STERLING RANCH - MARKSHEFFEL ROAD

STREET IMPROVEMENT PLAN

SEPTEMBER 2020

CDR-20-005

STERLING RANCH FILING NO. 2  
 FINAL GRADING & EROSION CONTROL PLAN  
 SHEET 7 OF 13  
 JOB NO. 25188.01

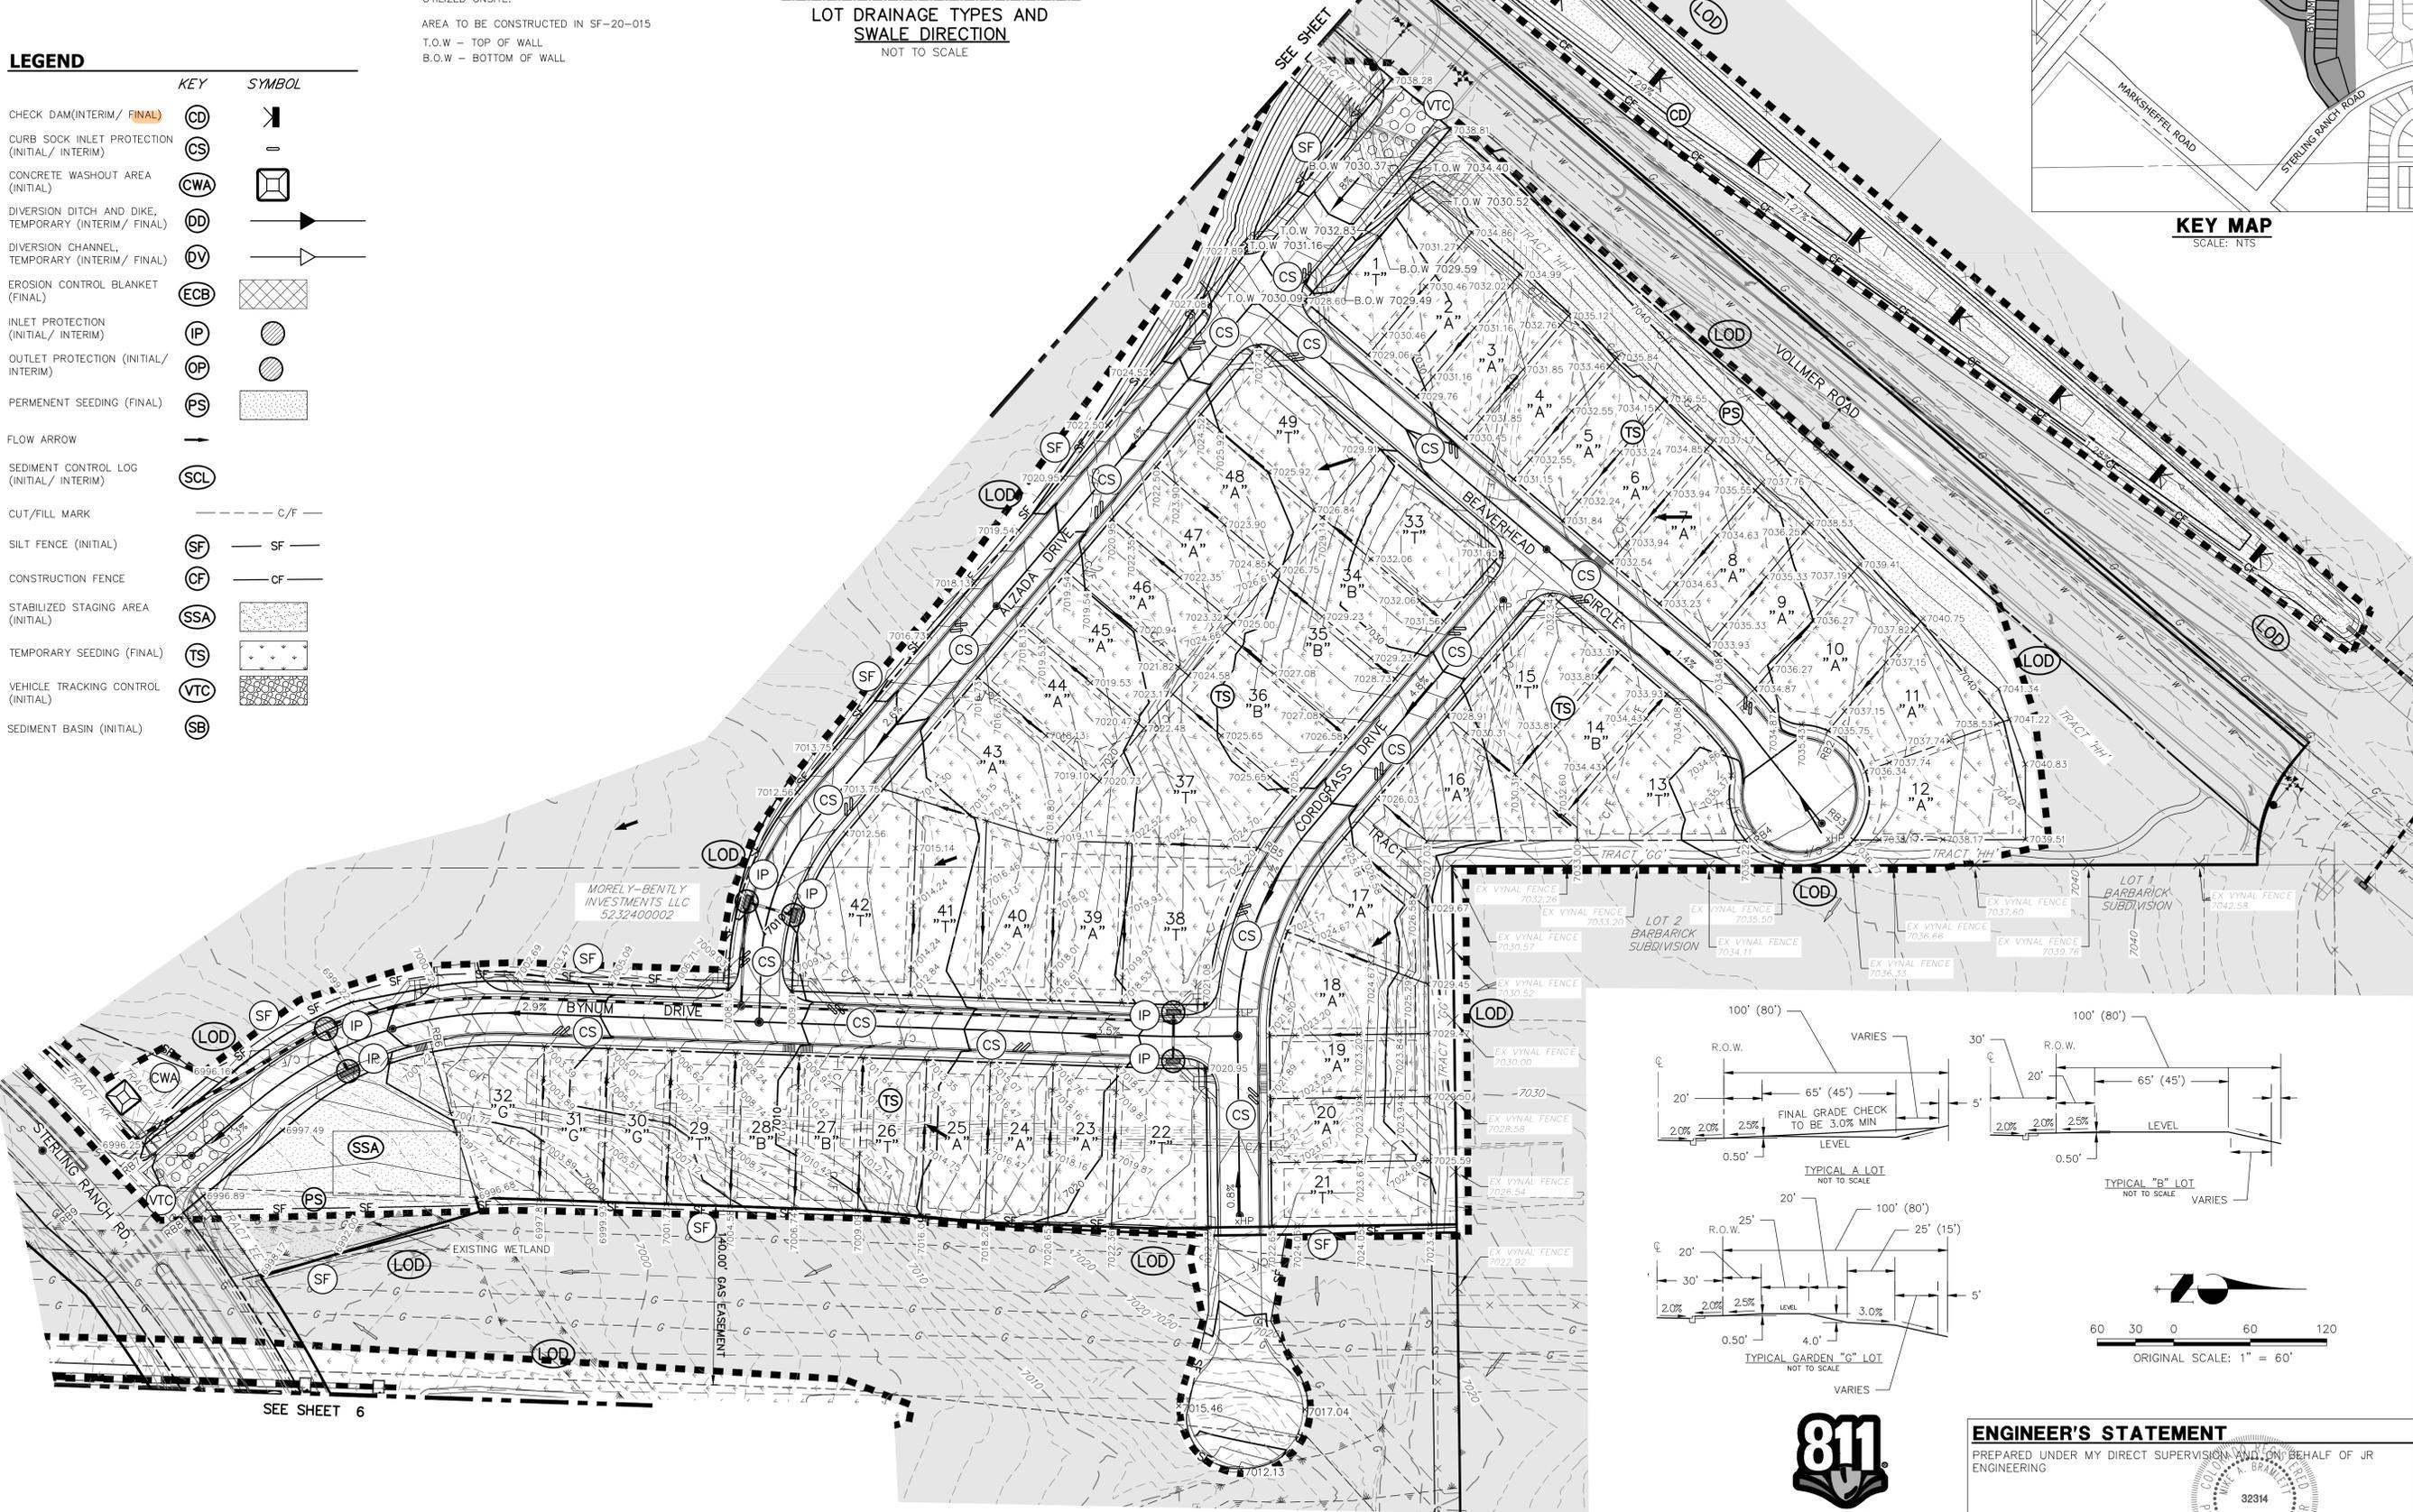
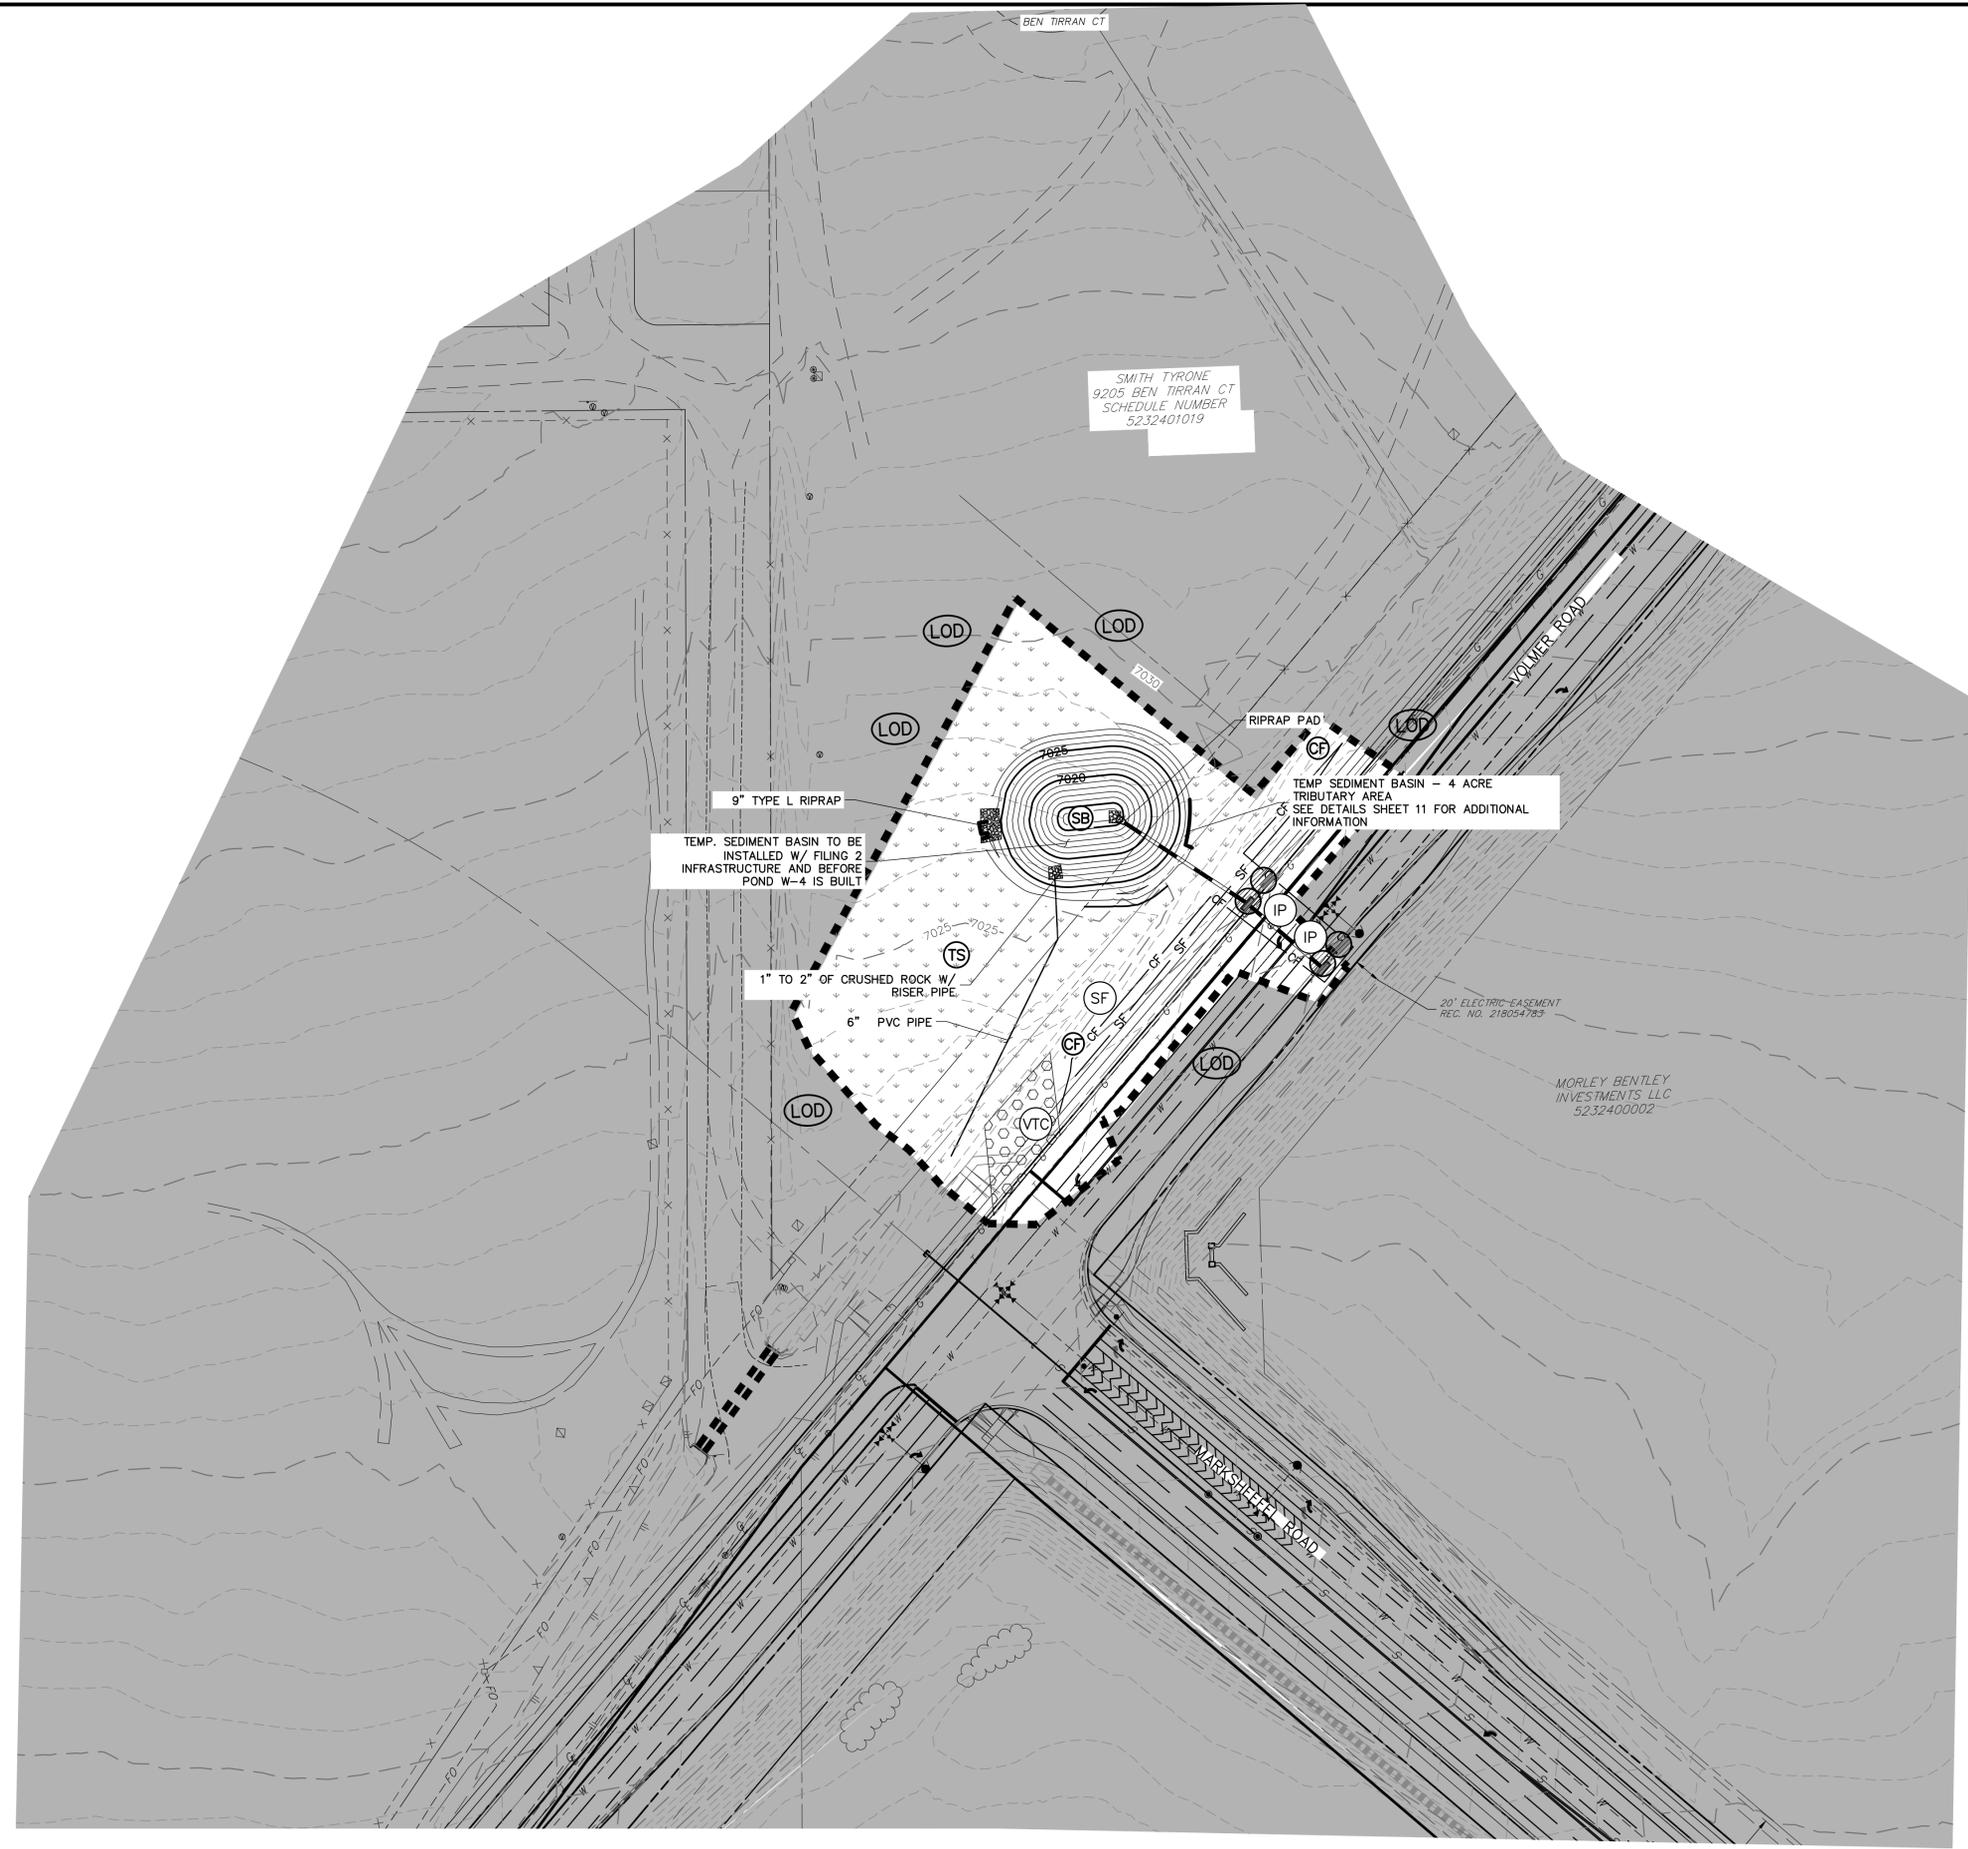
These silt fences don't make sense as shown (perpendicular to contours). Different BMPs would be appropriate if needed along the edges.

Does LOC end here for this set?
